631.30507-L01-v0.1-20220401.docx

Response to Request for Information 42 Honeysuckle Drive Newcastle NSW 2300

Thank you for your letter which requested further information (RFI) related to the Modification Application (Mod) for SSD 10378 Mod 2 located at 42 Honeysuckle Drive, Newcastle NSW 2300.

# 1.1 DESIGN CHANGES FIRST FLOOR

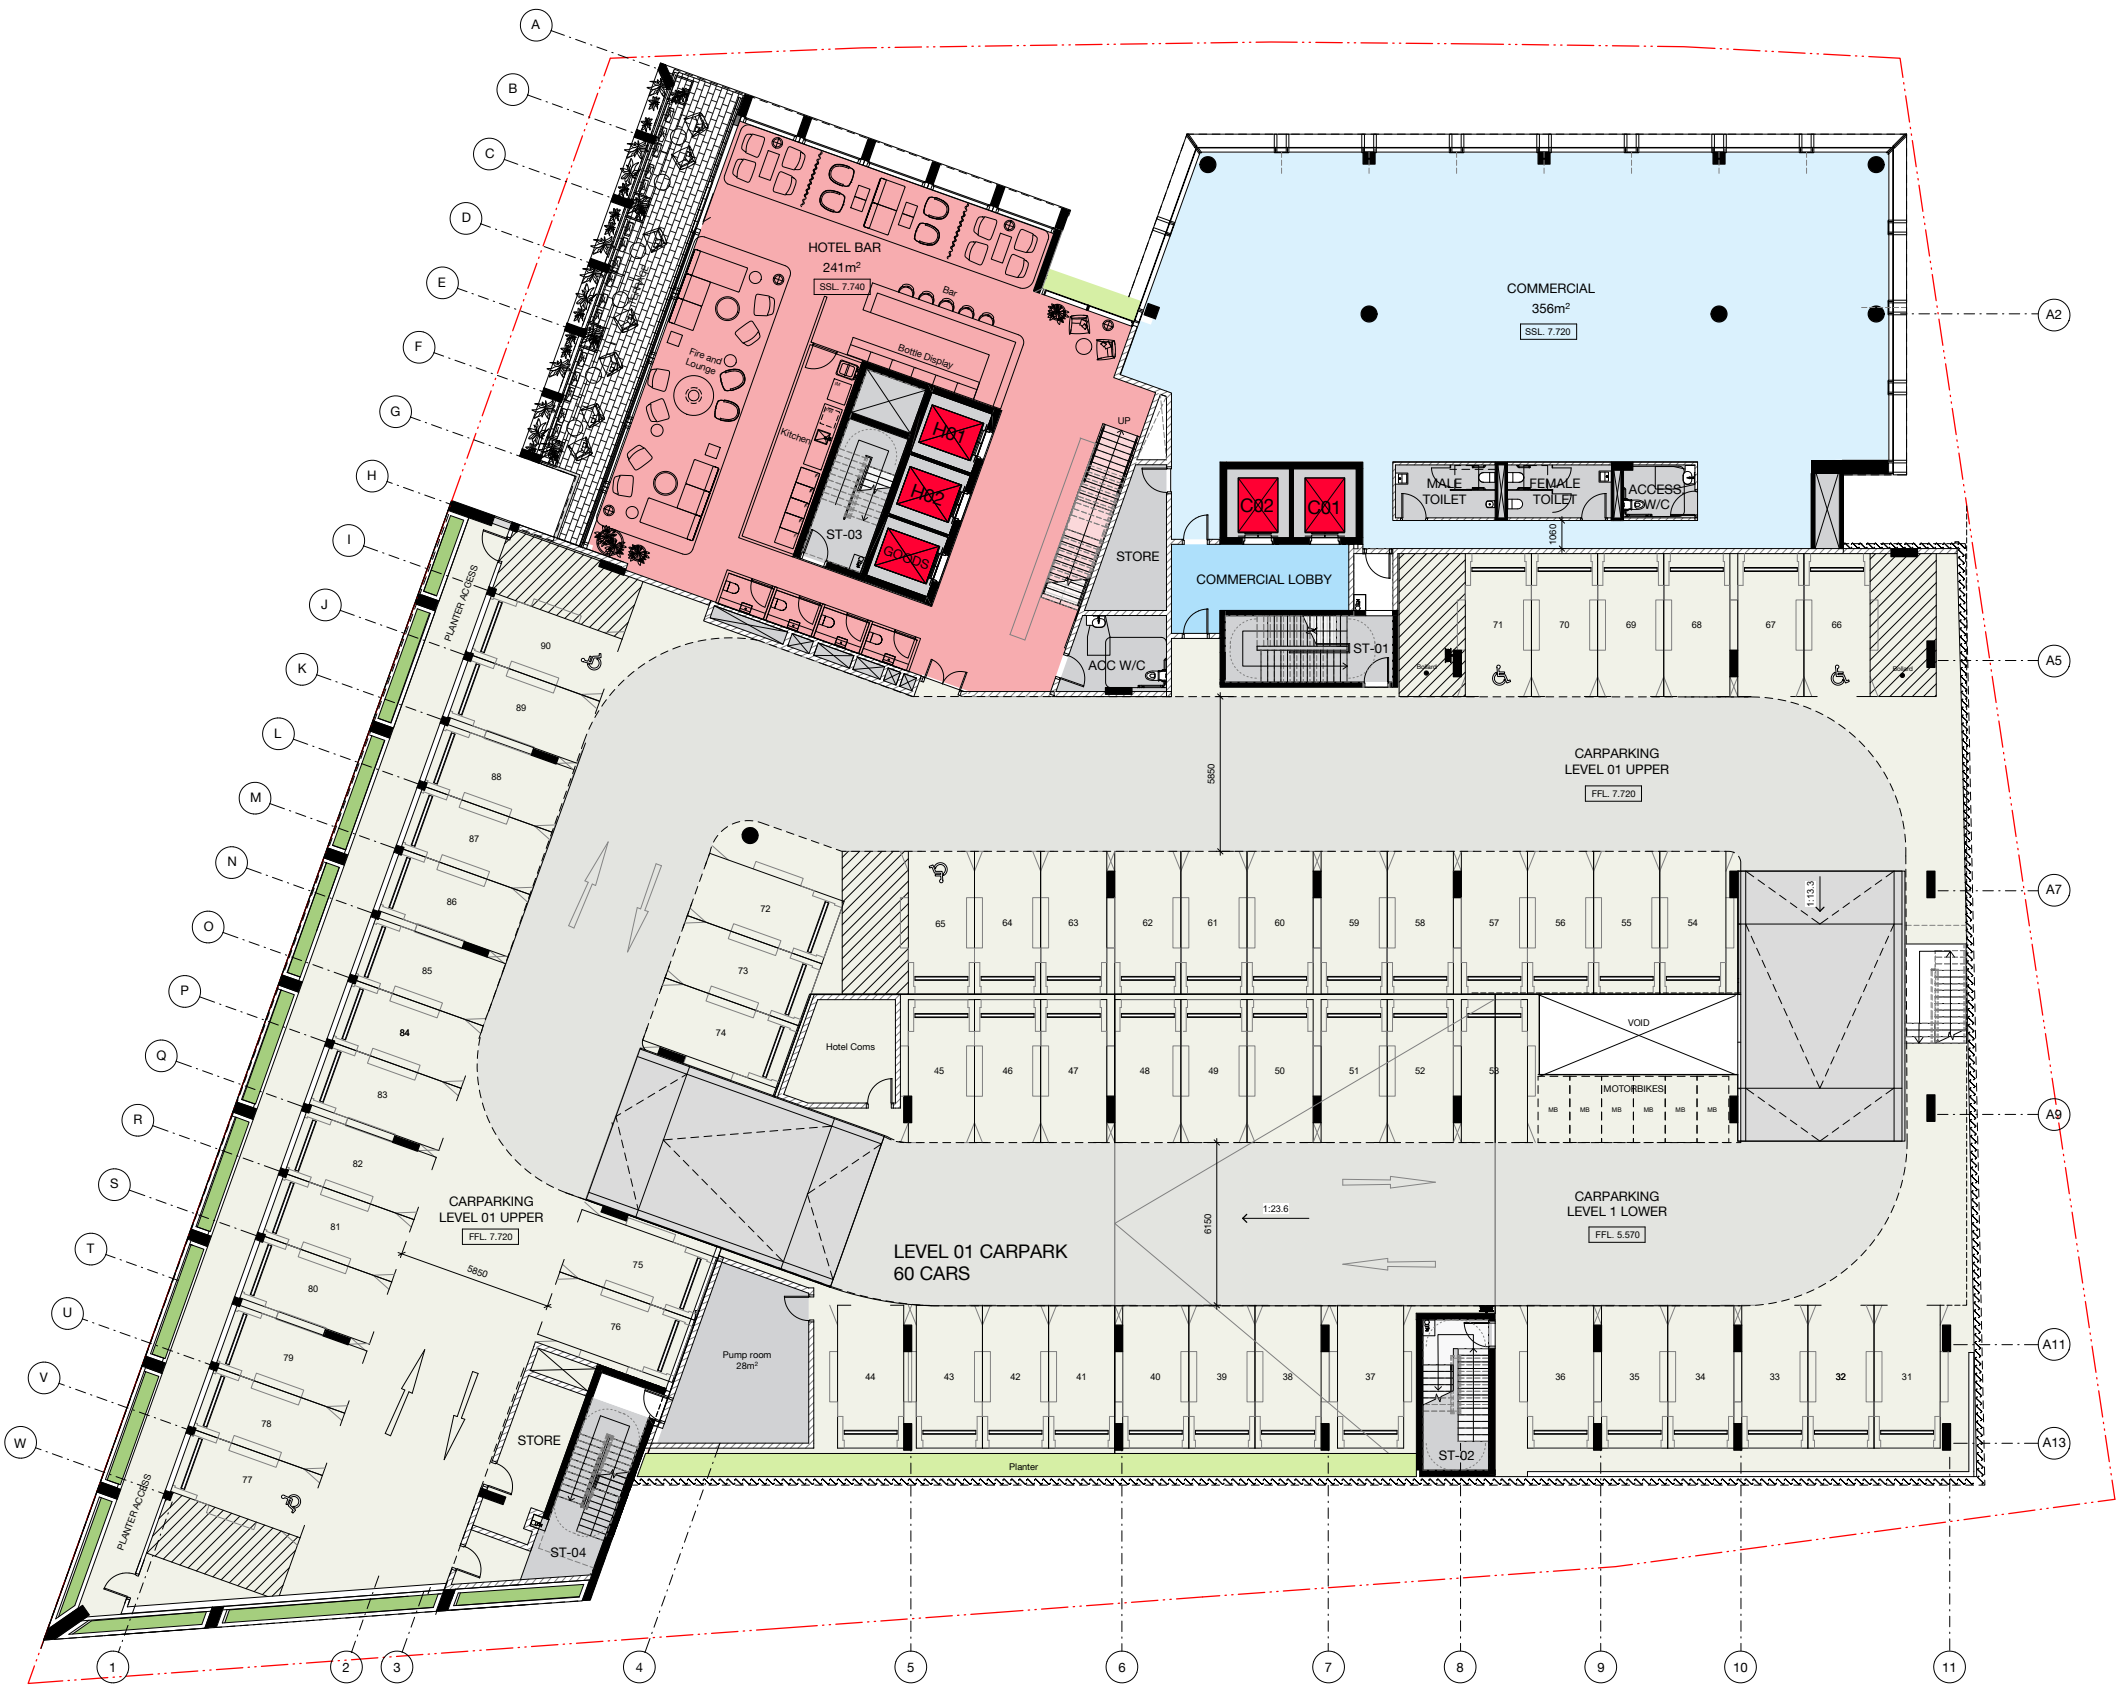
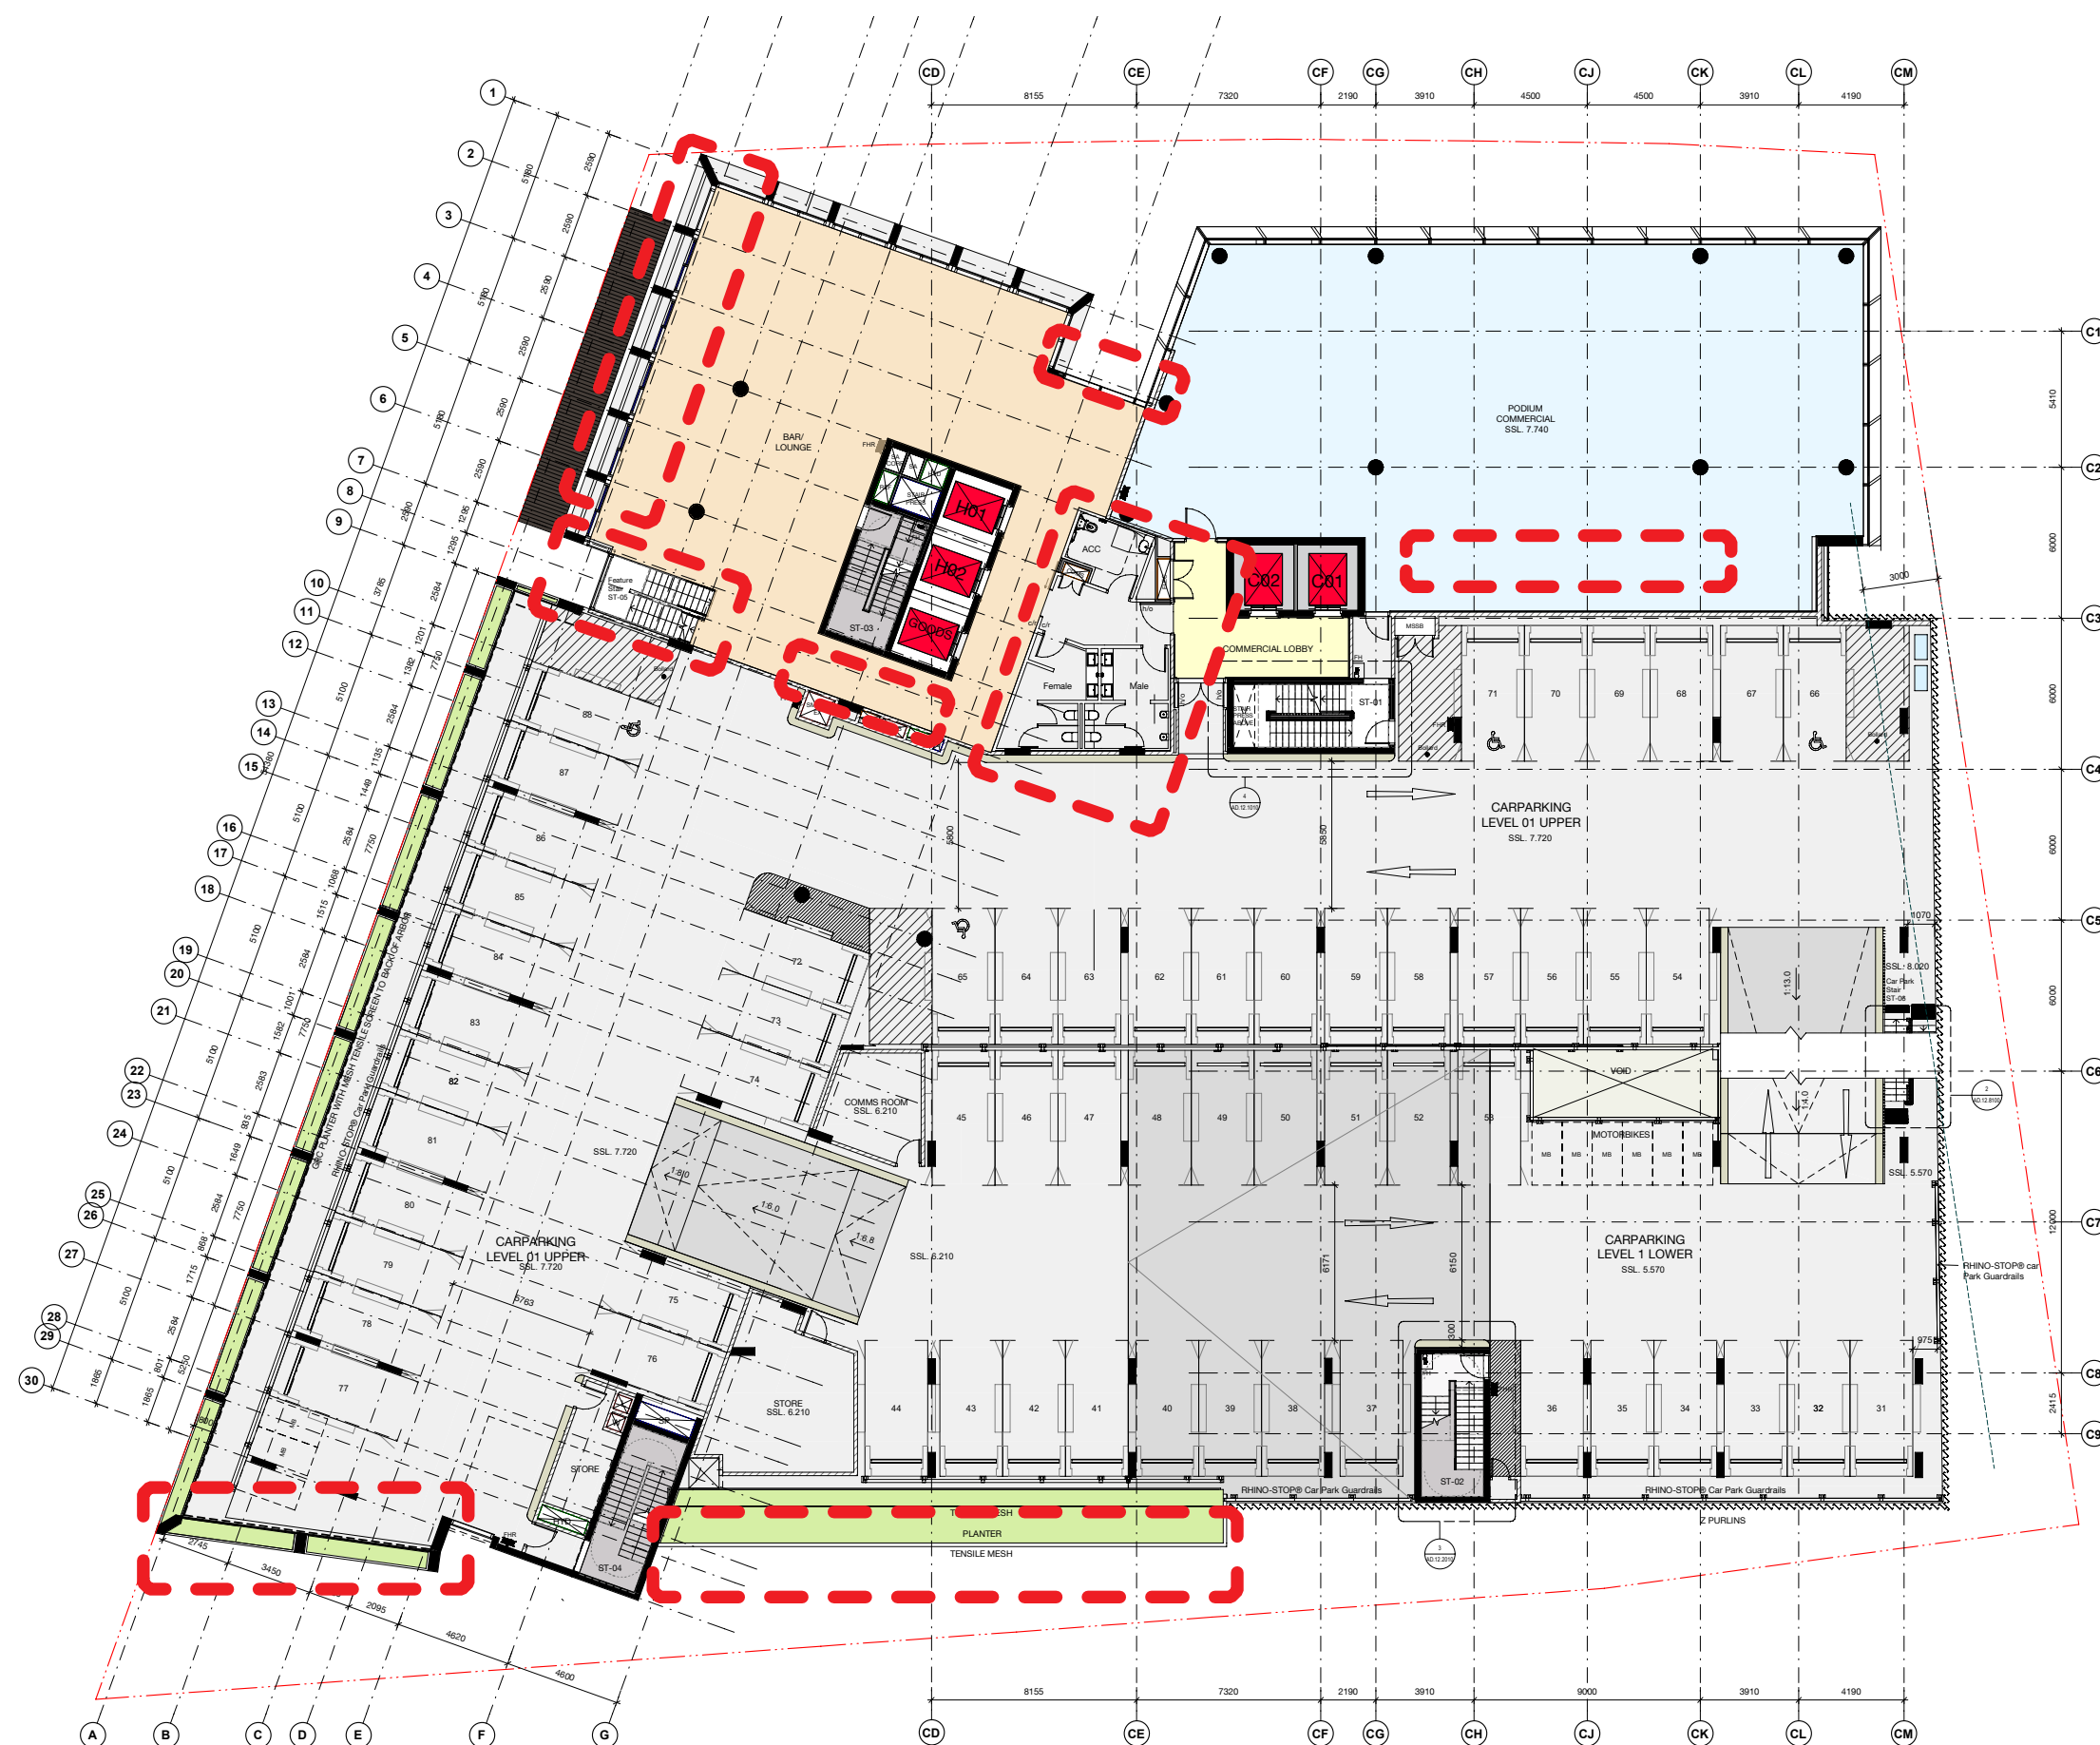
Item 6 of the 'Proposed DA Amendments' indicated on first floor plan in the Design Statement incorrectly refers to the loss of one parking space due to the proposed reduction in the length of the western elevation. It should state two spaces.

It is noted that two parking spaces for persons with a disability are being removed from the first and second floor car parking. It is recommended that the applicant is required to confirm that the remaining number of disabled parking spaces meets the relevant legislative requirements.

Noted, the correct parking amount is reflected by the proposed architectural plans provided.
